**EN010007 Wylfa Newydd Nuclear Power Station**

**Welsh Government (IP Number: 20011597) Deadline 6 Submission – 19 February 2019**

## Welsh Government Comments on the Phasing Strategy (Version 2.0)

Figure 2-1 Indicative Construction Timeline

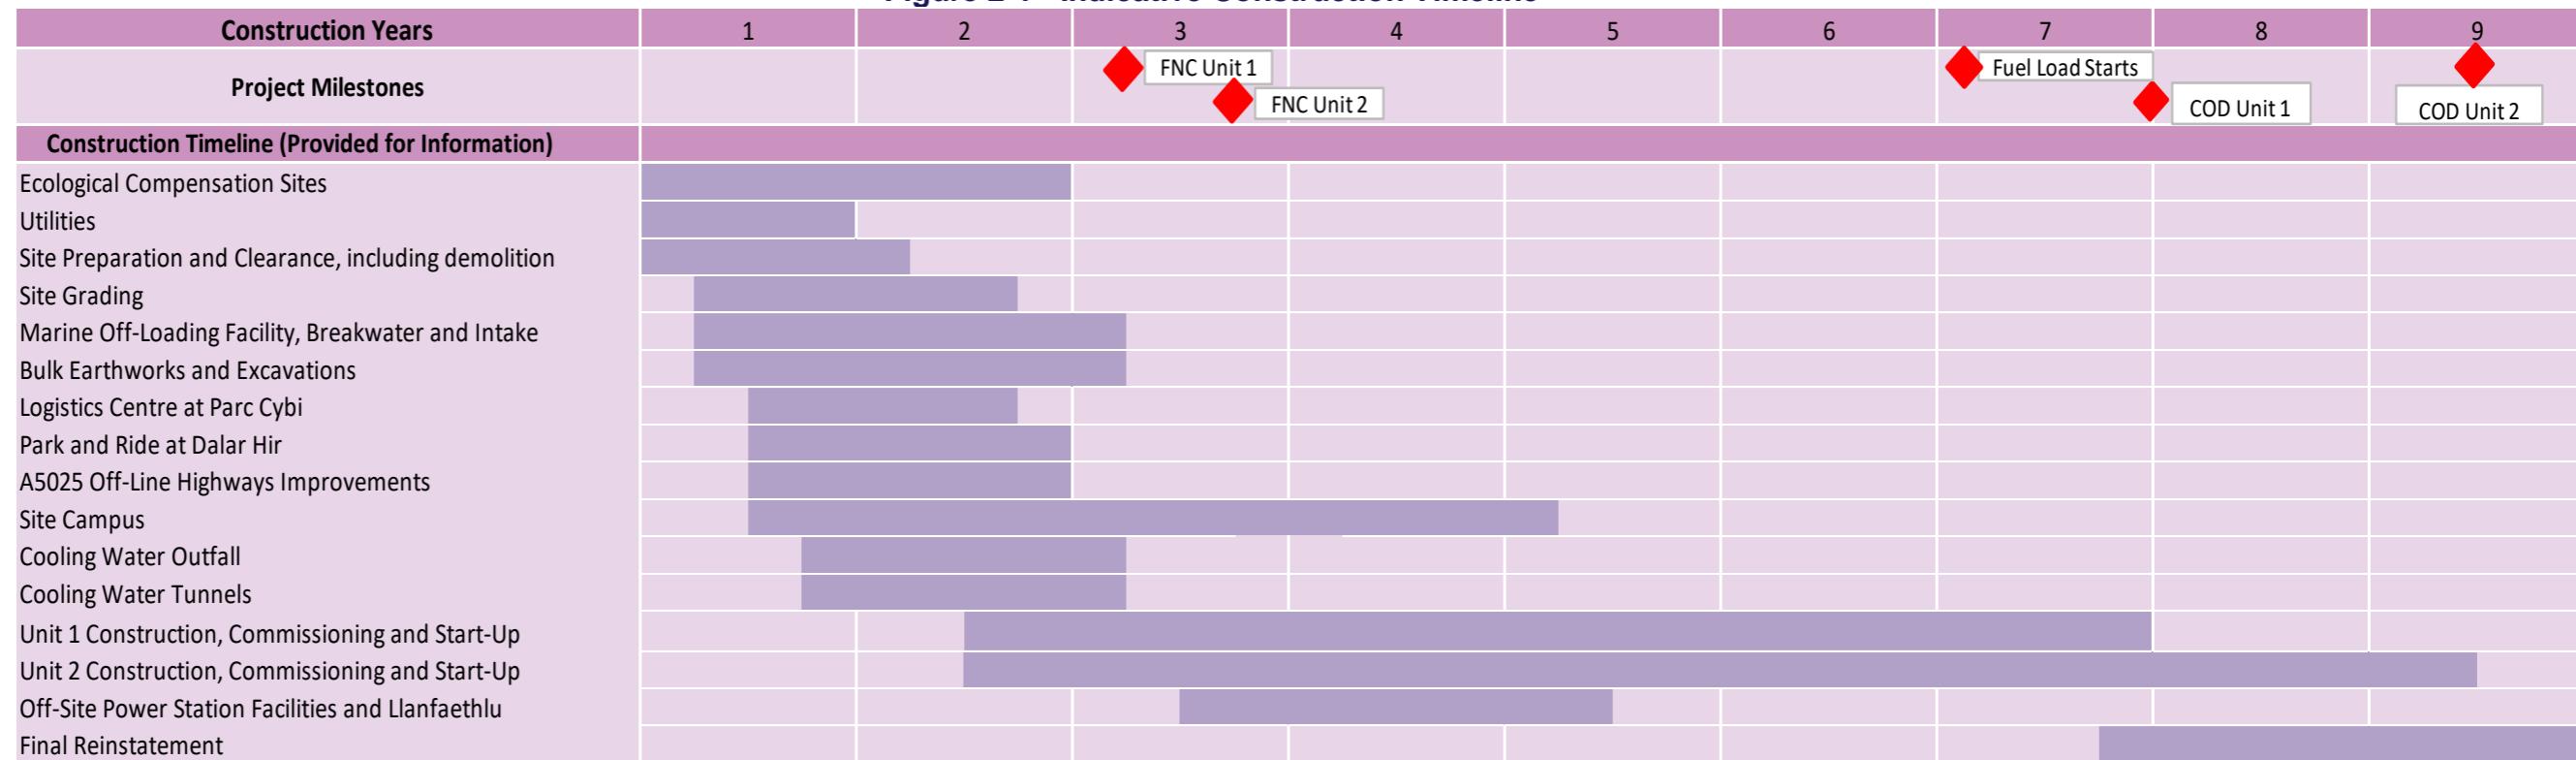
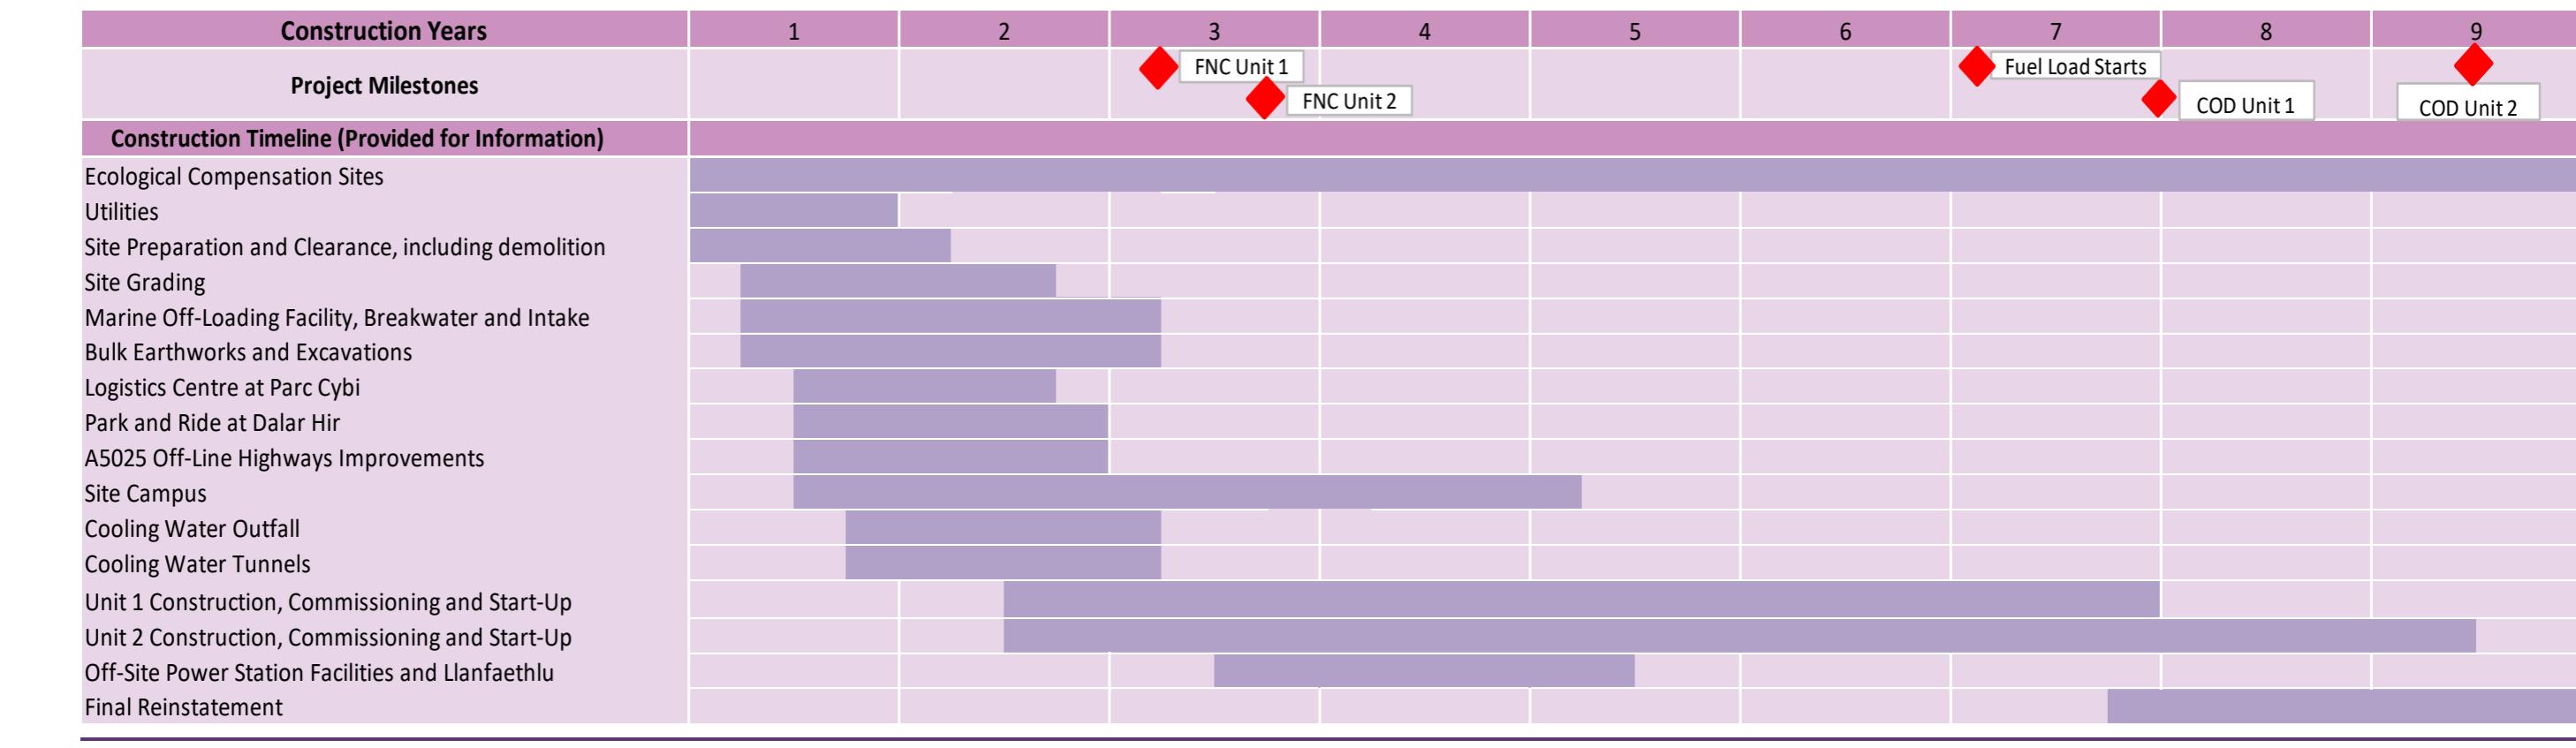
1.1.2 Introduction	PW2 - as drafted does not require notification to LPA when mitigation has been delivered.
Figure 2.1	Note that this is marked as "indicative" therefore if this is to be a control document it must be capable of enforcement. Therefore, use of the term "indicative" is not appropriate. The sequencing between each item is not clear. Therefore, as a control document it provides no control about preventing other elements from commencing if a previous element is not complete (e.g. work on MOLF, Cooling Water, and Unit 1 & 2 all set to start prior to Dalar Hir completion and opening - therefore significant increase in workforce prior to a key and necessary mitigation measure being available).
Figure 2.1	Can 'Year 0' be defined? (i.e is it first spade in the ground?)
Figure 2.1	The timeline does not show the timescale for, or when the decommissioning activities for the Associated Development will take place.

Table 2.1	"First two dry seasons" - what is the definition of a dry season? Is this wording precise and enforceable? What defines a dry season in Wales?
Table 2.1	<b>Logistics Centre</b> Statement does not align with Figure 2.1, which shows logistic centre completion after the start of Unit1&2.
Table 2.1	<b>A5025</b> Clarification requested - should restriction just be at "Valley" or "A5025" due to impact on villages along route - if there is a requirement that controls all HGV movements via Valley and onto A5025 then current wording may be ok - but not sure if this control is secured?
Table 2.1	<b>Park &amp; Ride Facility</b> Again Figure 2.1 does not align with this statement. Also (as discussed on 23rd January 2019) there should be a pre-delivery restriction based on capacity of parking on site, which is linked to worker numbers [NB: it is also not clear (and we would welcome clarification from the Horizon Construction Team) why it would not be possible to deliver the 1,900 spaces in phases to allow an earlier opening of the P&R.]

Table 2.1	<b>Site Campus Phasing Strategy - requests for earlier delivery of TWA</b> This change to worker numbers has not brought the delivery of the TWA forward to earlier in the build programme. WG are still concerned that this is not early enough and see no reason why construction of the campus could not be completed sooner than Q1 year 5. Horizon's response to this query in their TWA Position Paper (Appendix 1-1 of Actions set at ISH 7 January) states that the current programme for Phase 1 of the TWA (including procurement, design, manufacturing and installation) is estimated as 22 months, which therefore equates to Y2Q4. 1st Phase would still allow 2,200 NHBW before any TWA units are made available (therefore 73% of off-site provision could be taken up before alternative accommodation choice is available - creating more demand and rental pressures on stock in the early years).
Table 2.1	<b>Site Campus Phasing Strategy - 'Essential Workers' for First Nuclear Construction (FNC)</b> It is also understood that at least 500 bed spaces are required onsite for 'Essential Workers' during nuclear concrete pour. According to Fig 2.1 this would be around Y3Q1, and not Y4Q1, which is when workforce predicted to hit 2,200.
